Re: Design Advice Letter

This project (**SSD-94409457**) was declared State Significant Development (**SSD**) by the Minister for Planning and Public Spaces on 23 July 2025 per the recommendation by the Housing Delivery Authority (**HDA**) and includes a concurrent Rezoning Proposal to increase the height and floor space ratio permissible on the site. This project seeks consent for a 45-storey residential flat building comprising 63 market dwellings and 51 affordable housing dwellings, ground level communal open space and basement carpark.

Title
C2- MATERIALS & FINISHES
MATERIALS & FINISHES

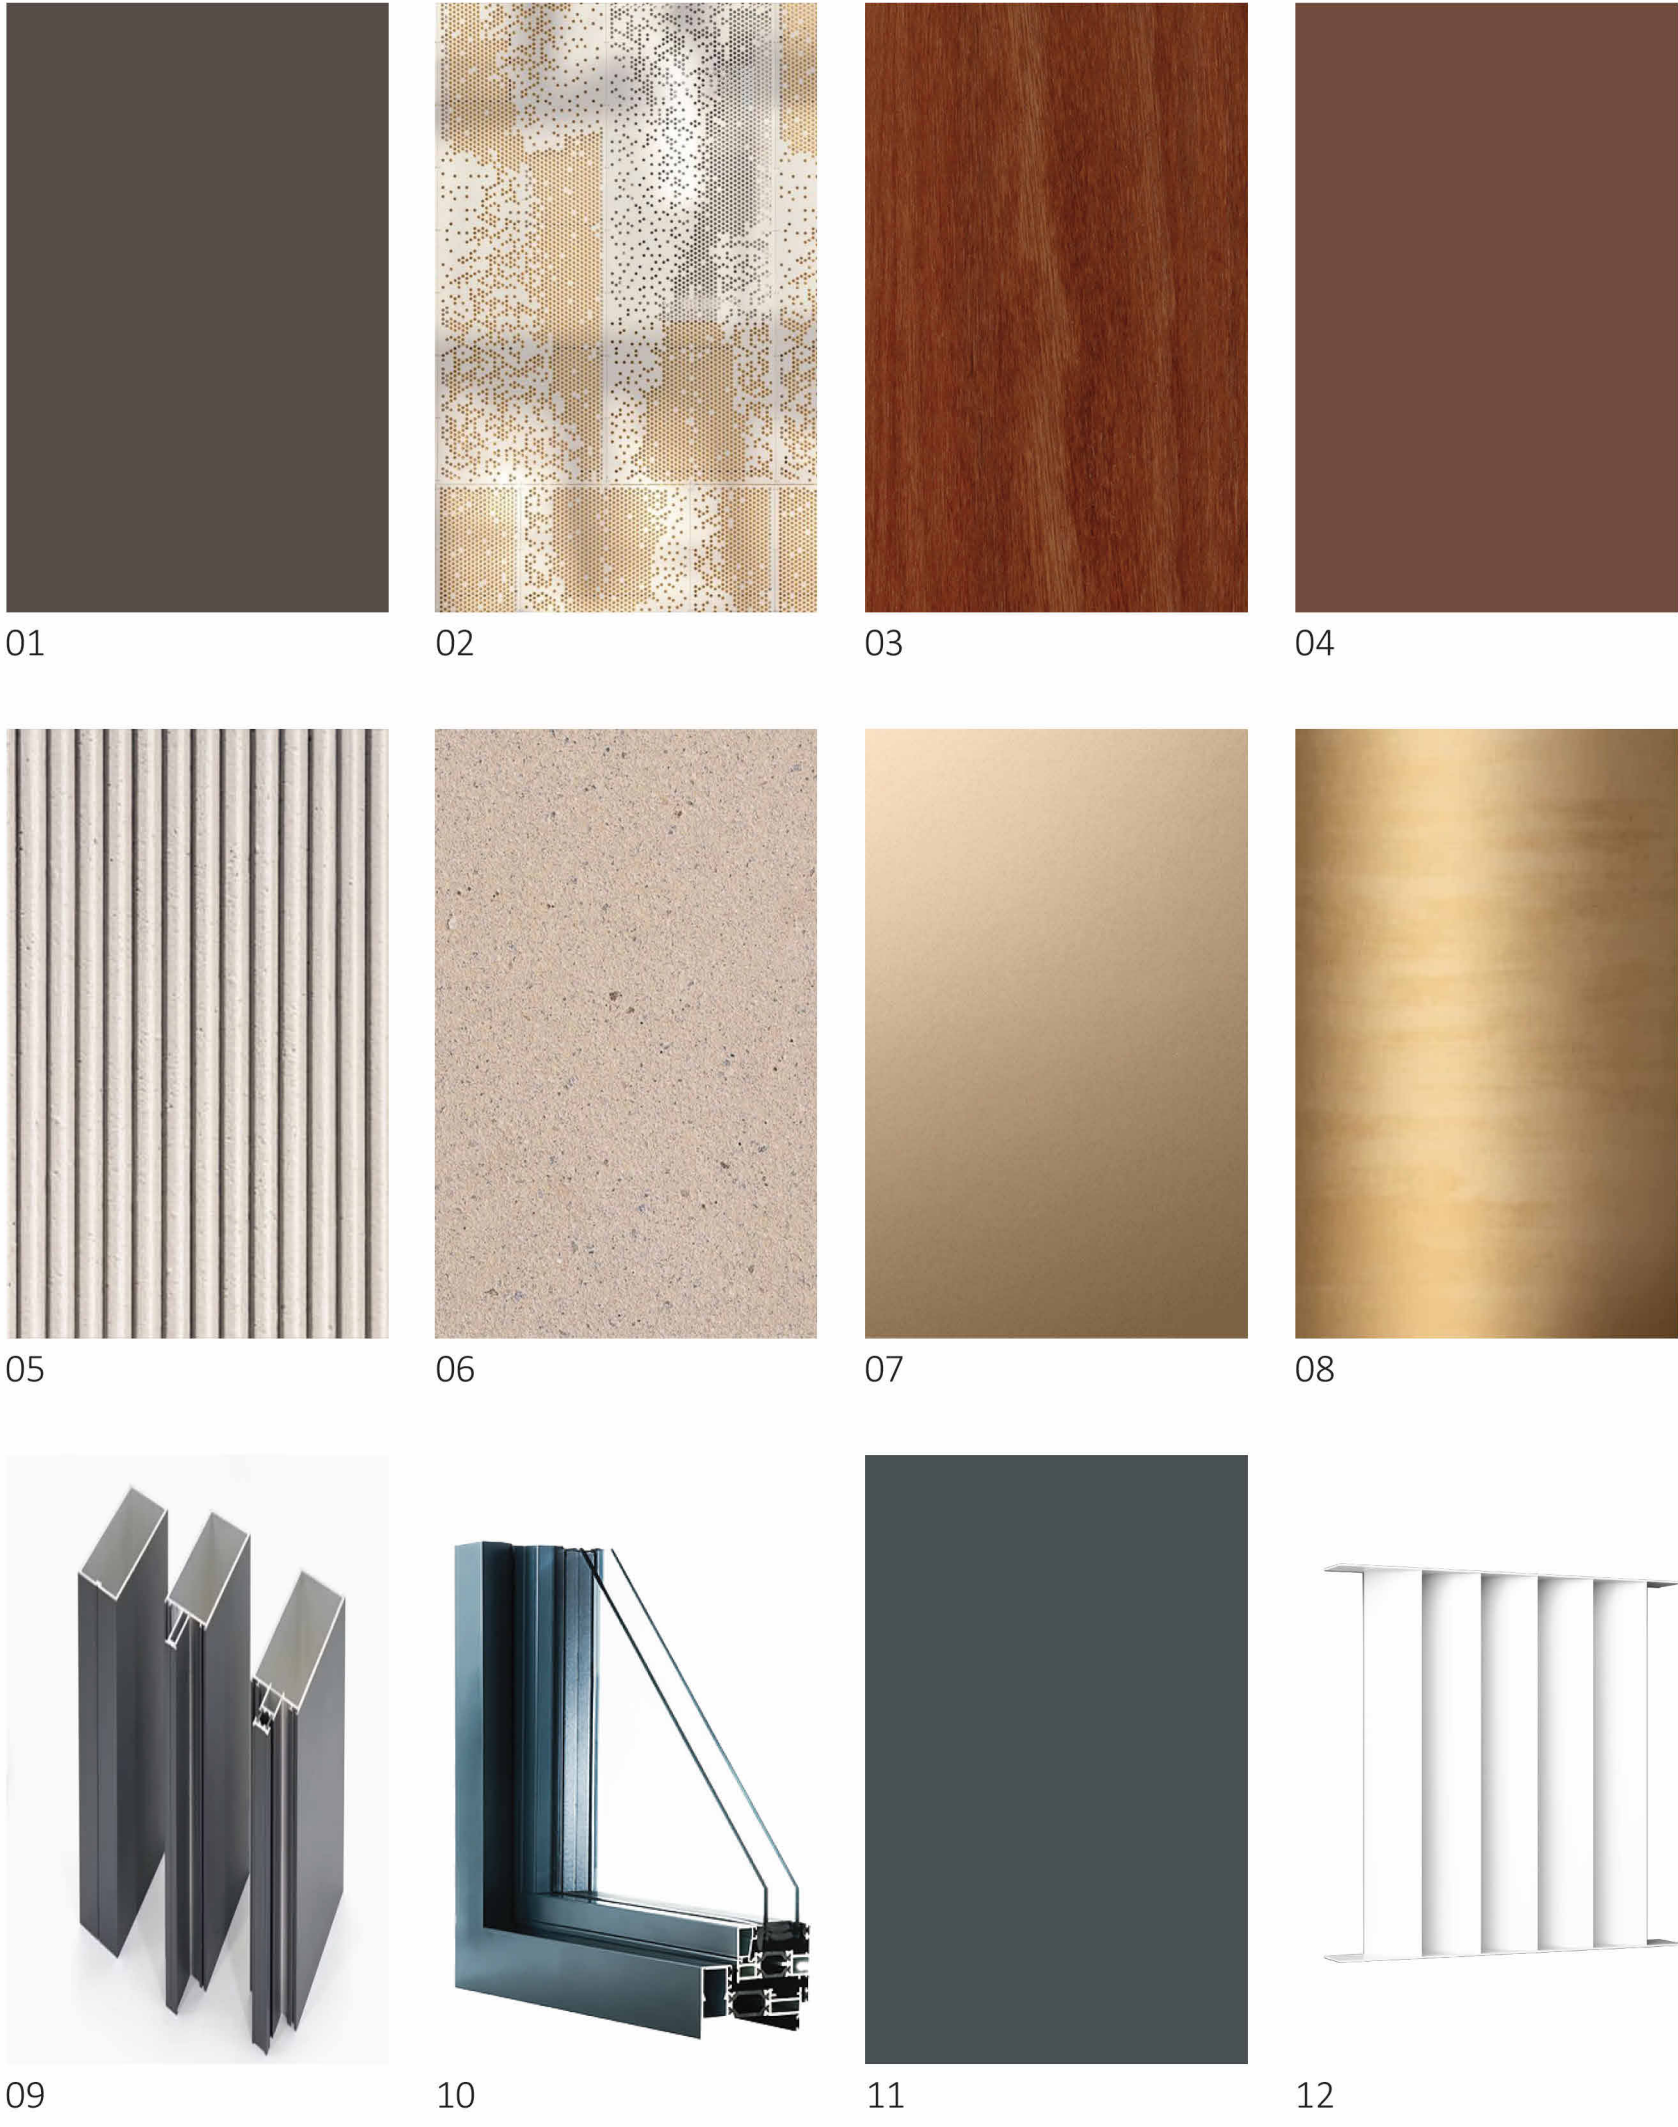
- The Applicant is to demonstrate commitment to noble materials.

- Commitment to noble materials

3.3 LANDSCAPE PLAN -GROUND FLOOR

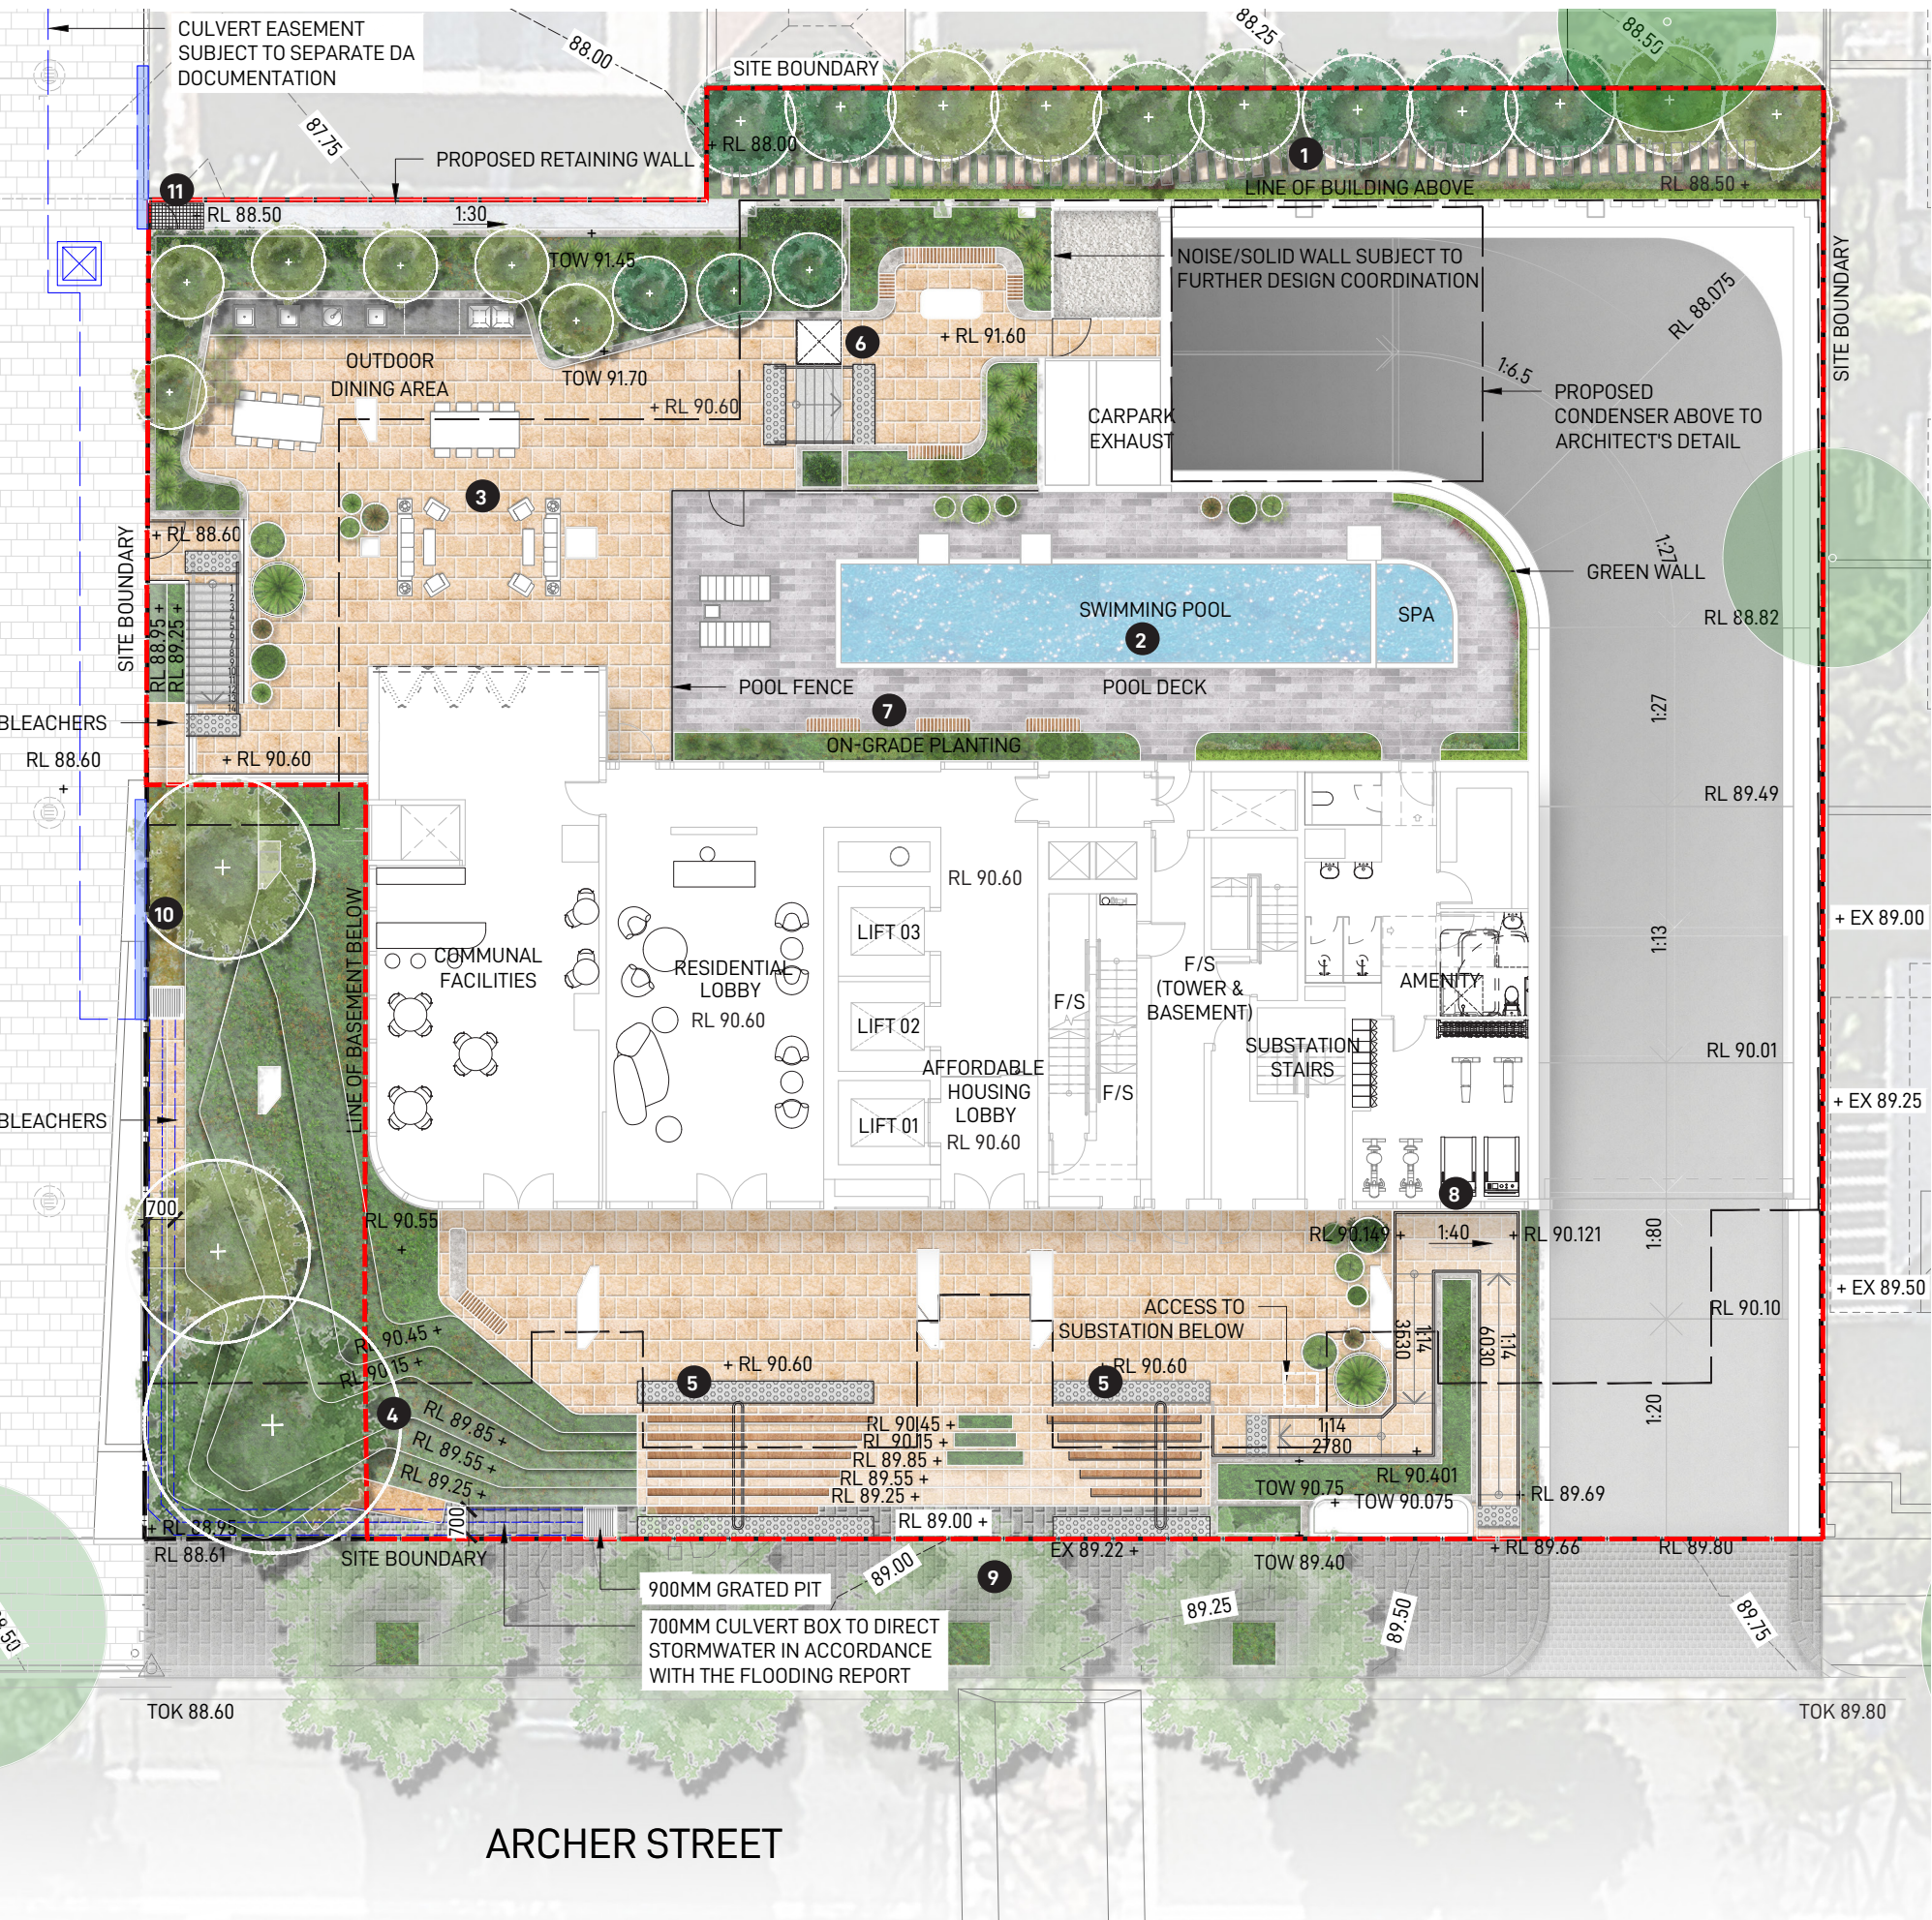
- Streetscape analysis to be undertaken to inform the design of the interface to the recently approved development to the north at 57-61 Archer Street and 34 Albert Avenue.
- Consideration is to be given to the overshadowing impacts caused by the approved development to the north. What would the interface look like in winter when there is not much sun and does the planting schedule reflect this environment?

- The current design of communal open space at the north eastern corner of the ground plane poses potential privacy impacts to the adjacent dwelling at 32A Bertram Street. The design team is to review the design and address any potential privacy impacts on the neighbouring property. Consideration to be given to both existing and future, potential uses of this site.
- Remove the platform lift/hoist and replace with an accessible ramp providing better equity of access. Potential to consider integration with Design for Country approach.

- Revision to the communal open space at the north eastern corner to address privacy concerns to the adjacent dwelling at 32 Bertram Street
 - Removal of platform lift/hoist replaced with an accessible ramp and consider integration with Design for Country approach
